Subject: A/84/21/DOC

I refer to Application A/84/21/DOC. I realise this is a Discharge of Conditions application upon which you would not normally invite public comments.

My comments upon **Condition No 23** – maintenance and management of sustainable drainage scheme (SuDS) are:-

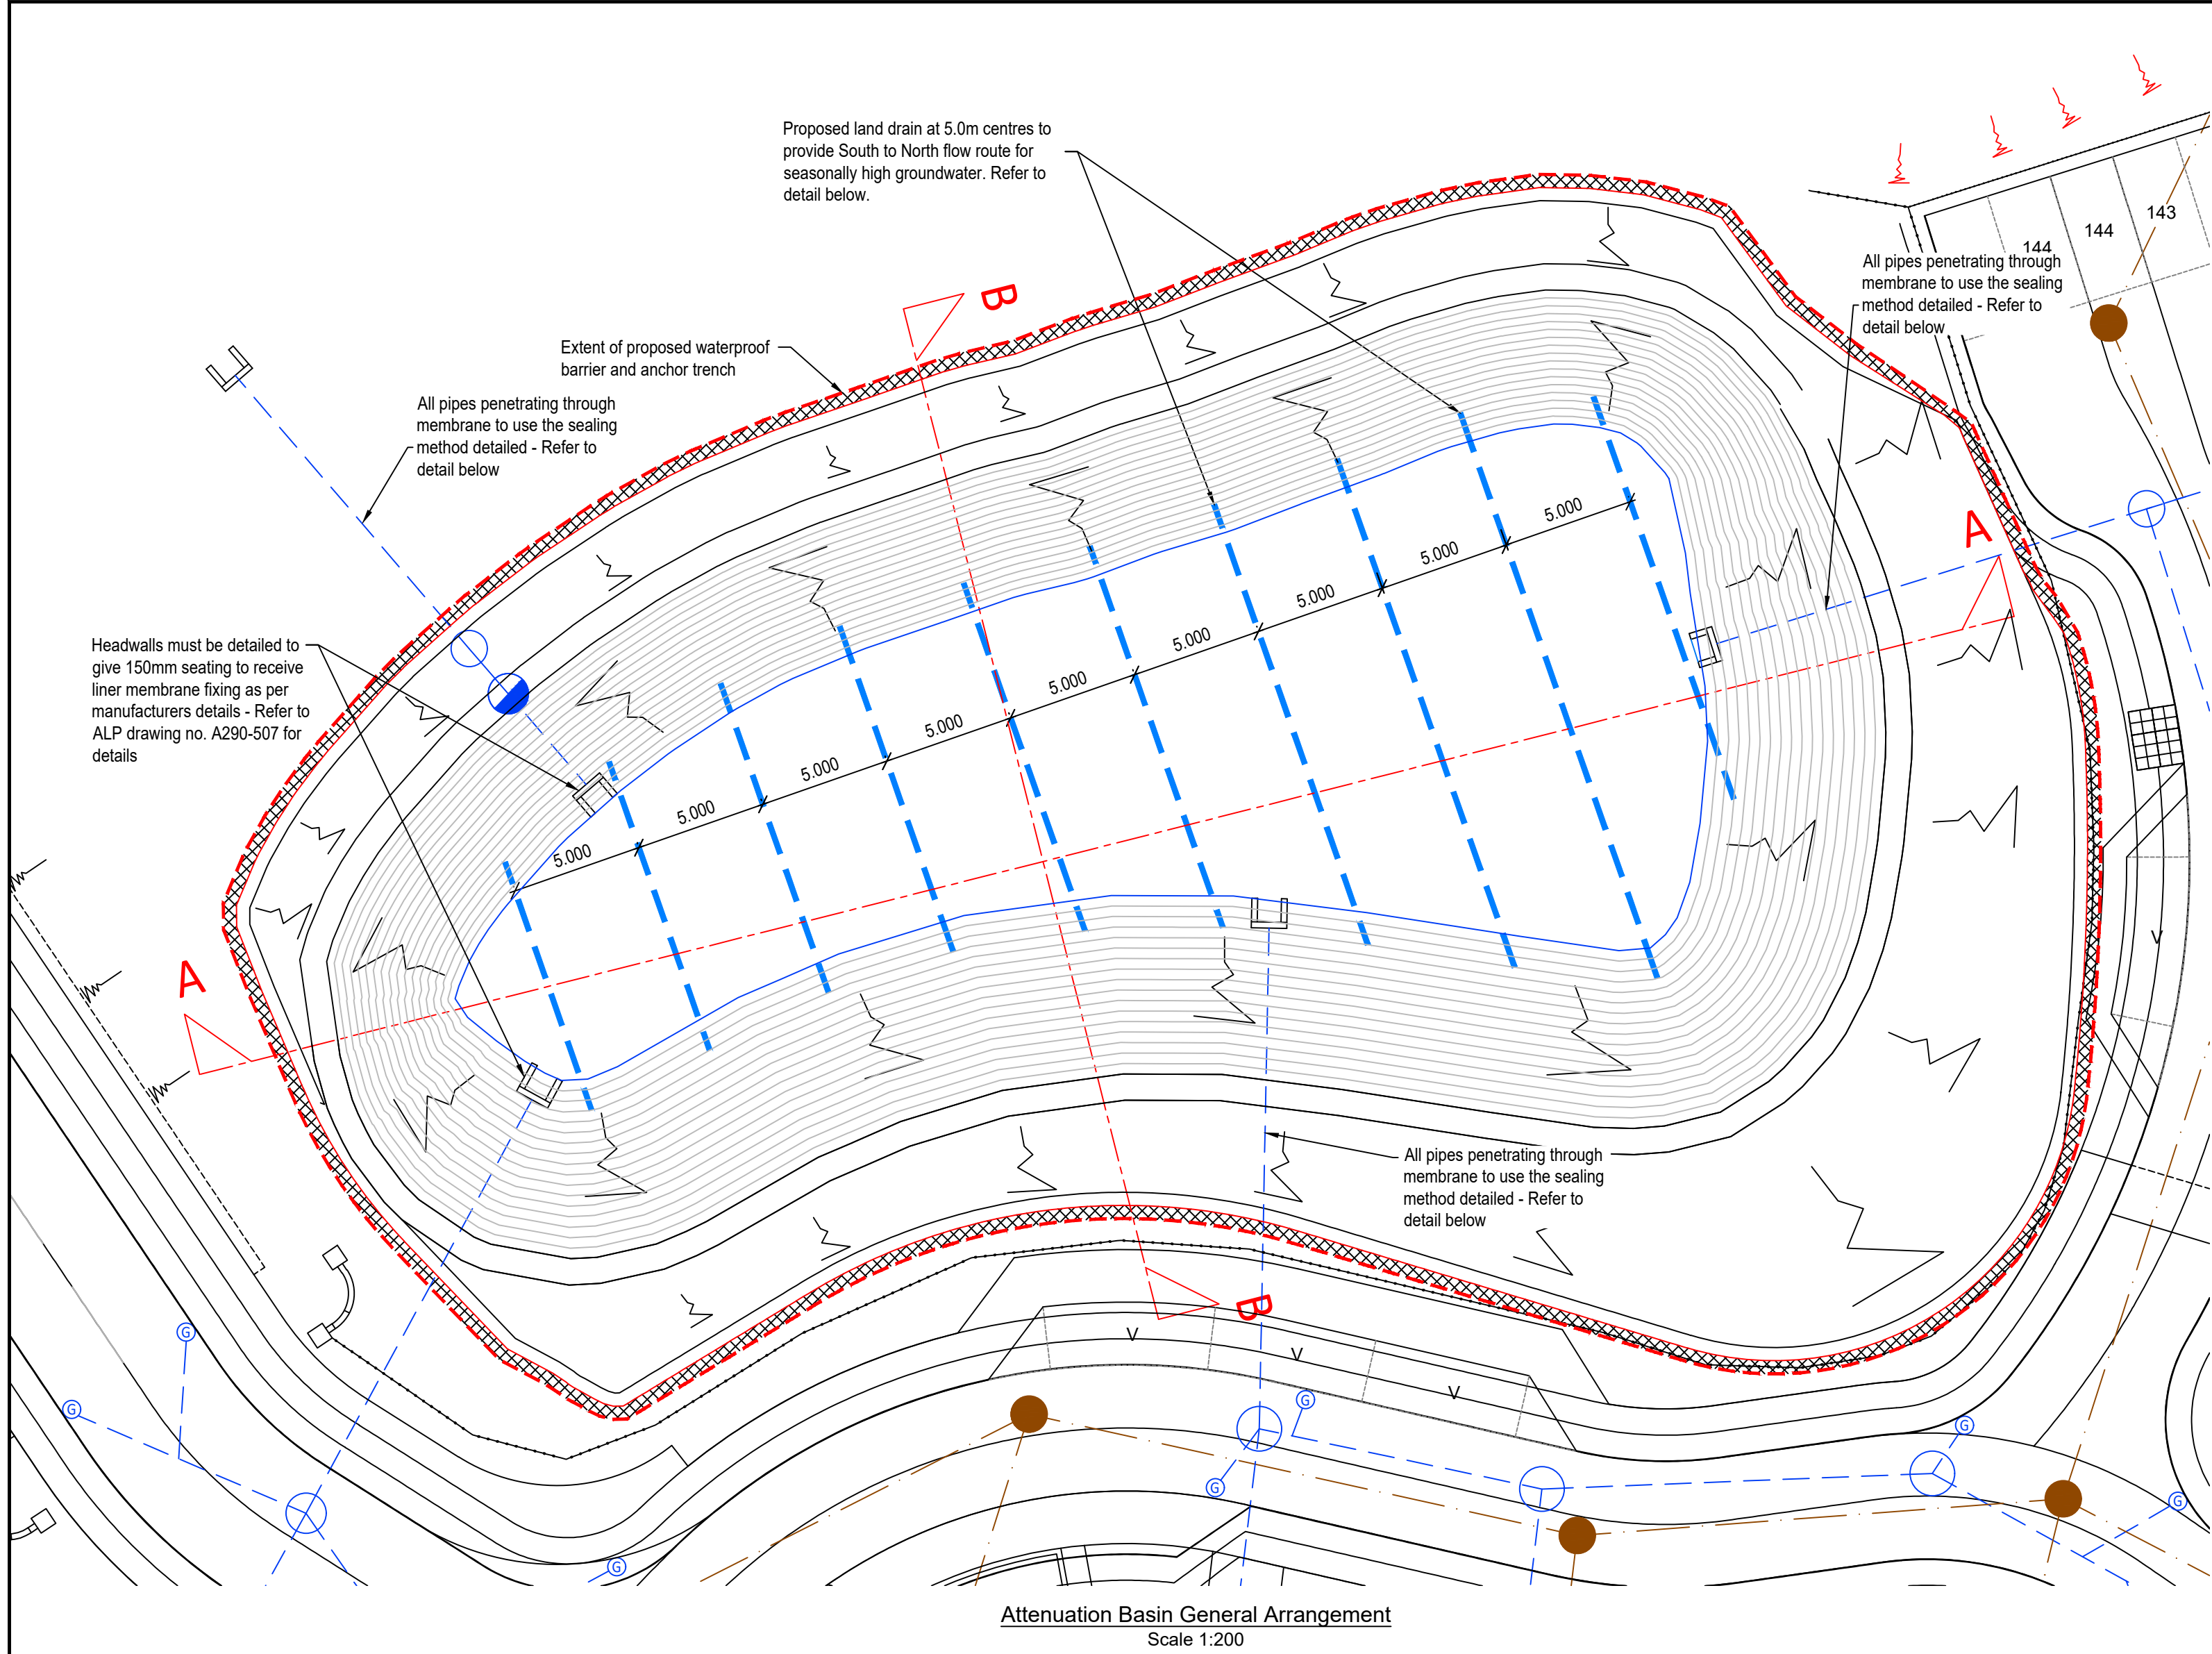
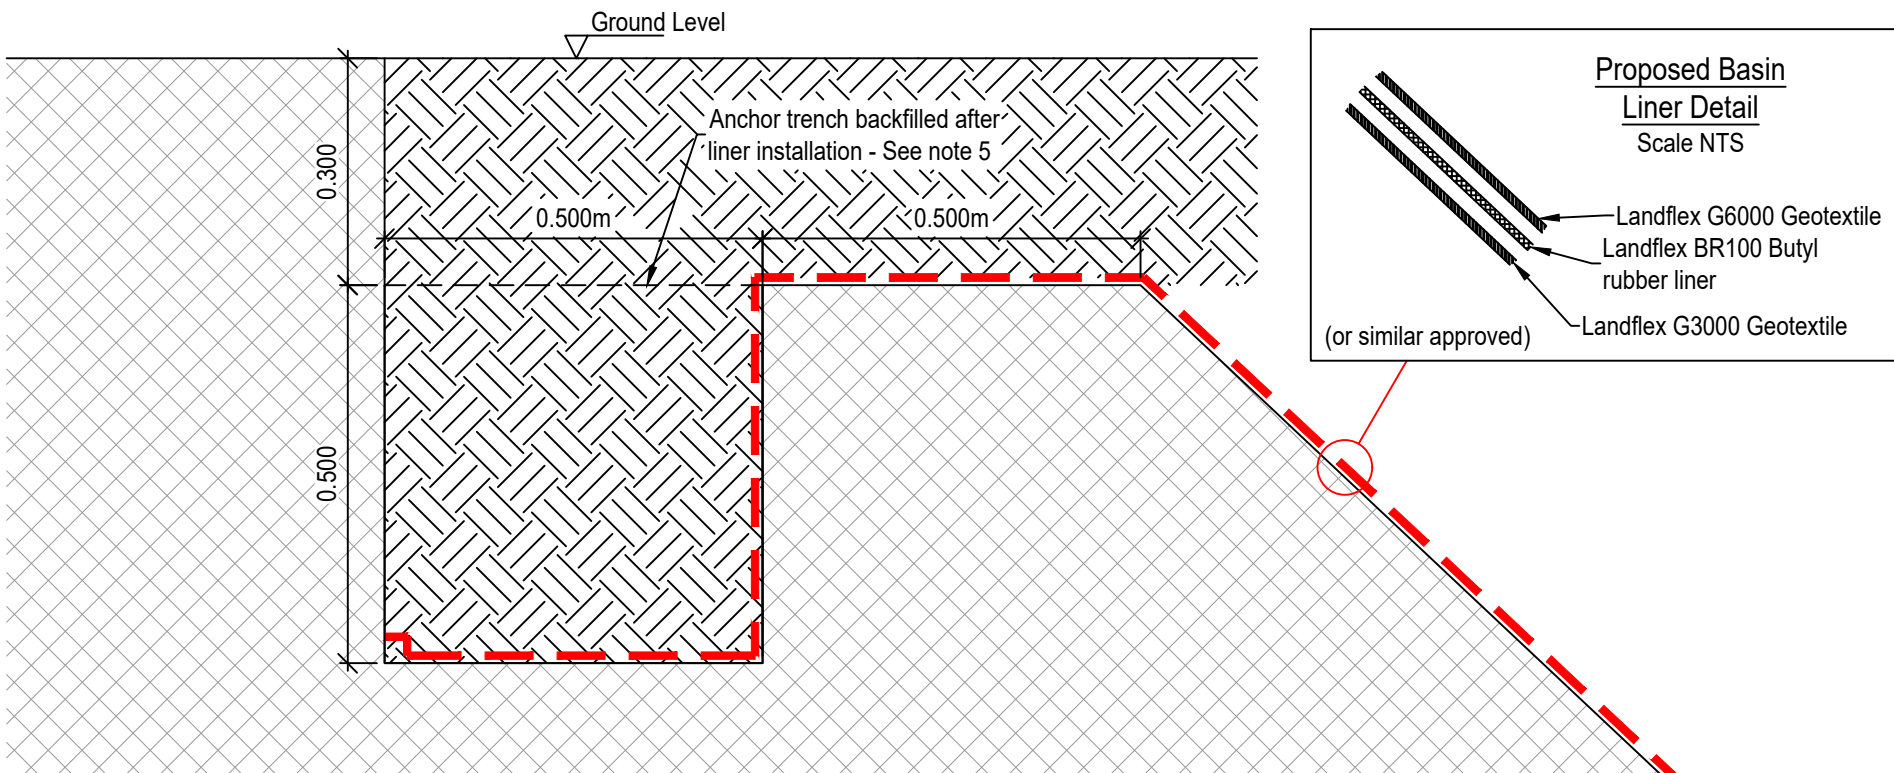
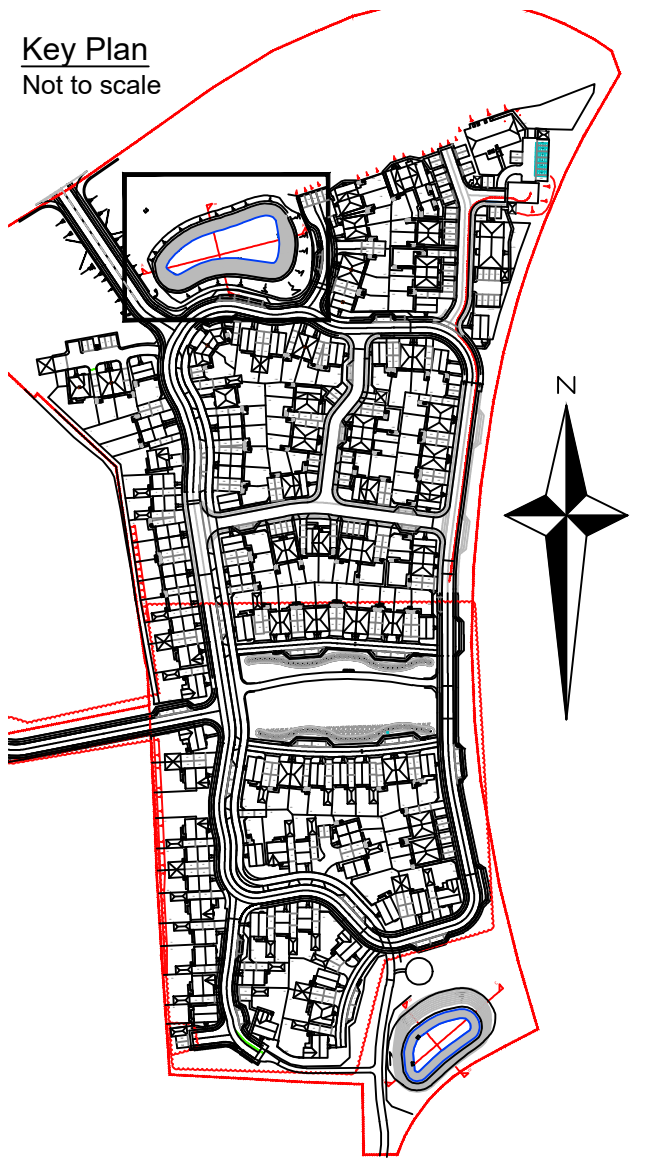
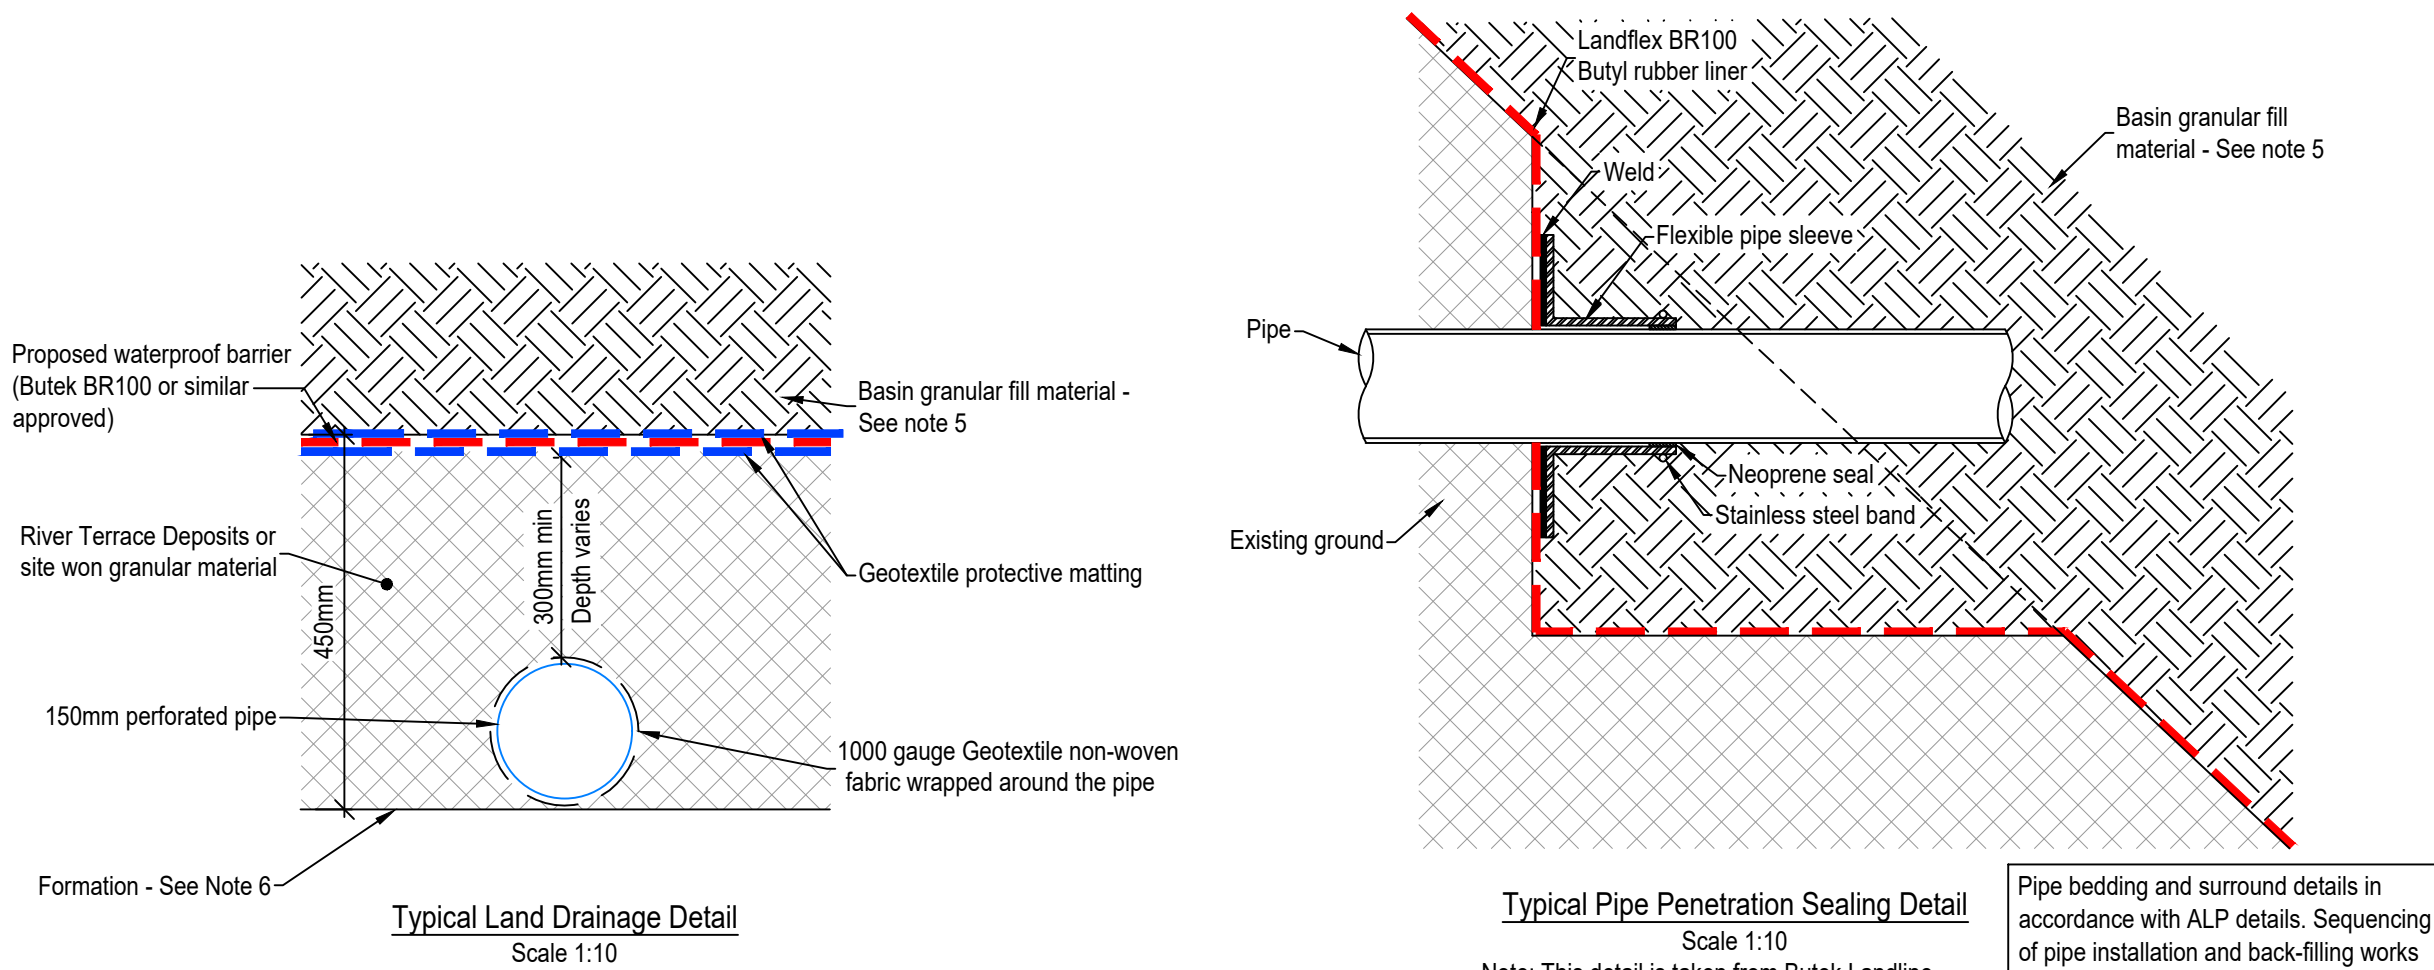
Lining ponds to resist flotation is always problematic. What seems to be proposed here is that the lining is at a level below that of the outlet and covered with granular (gravel and sand) material to resist flotation. Presumably, the lining will also retain water to the level of the outlet and thus the area could be unpleasant at times.
